S Harnett County - Application Tracking Individual Step Mai...

Application number 09 50022558
 Application type CP NEW RESIDENTIAL (SFD)
 Revision number
 Path/Step/Seq/Agency A 10 00
 Date submitted, resulted 81409
 Status code
 Reviewed by
 Revised est cpl date 81309
 Copies of plans

PLOT PLAN
 OF
LOT 9
JONATHAN RIDGE
HARNETT COUNTY
 FOR
SCOTT LEE HOMES
 SCALE: 1" = 40'50"

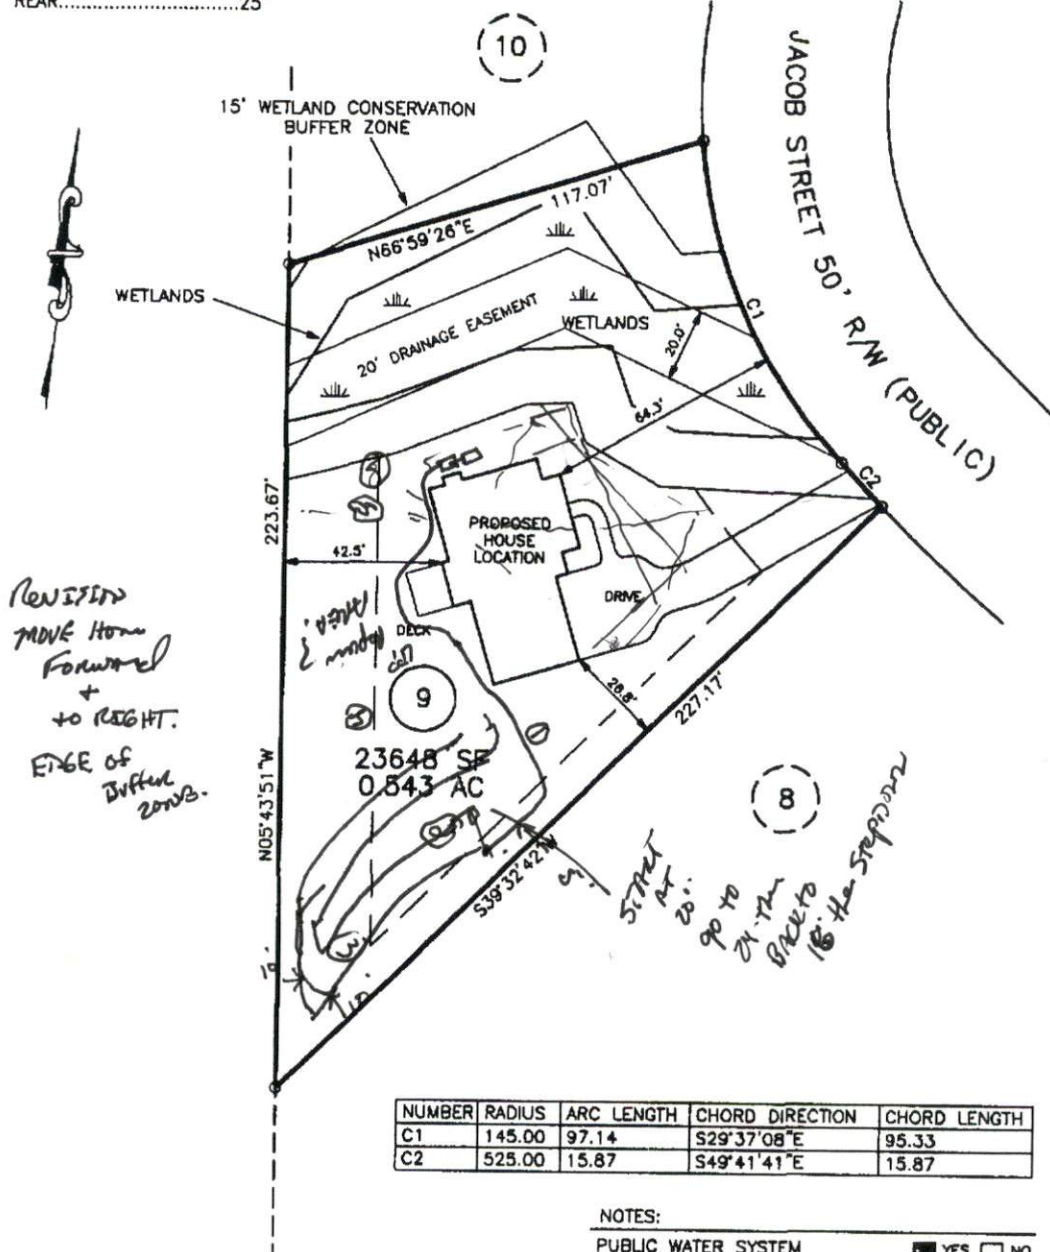
| Seq | Comments | Prt | Date |
|-------|--|-----|-------|
| 1.000 | MARK BACK PROPERTY LINES. T/S: 08/14/2009 11:20 AM SSTEWARD ----- | | 81409 |
| 2.000 | T/S: 09/04/2009 11:13 AM SSTEWARD ----- CALL 893-7547 TO SCHEDULE A MEETING WITH JAMES MANHART TO SCALE OUT AVAILABLE SPACE FOR HOUSE PLACEMENT. | | 90409 |
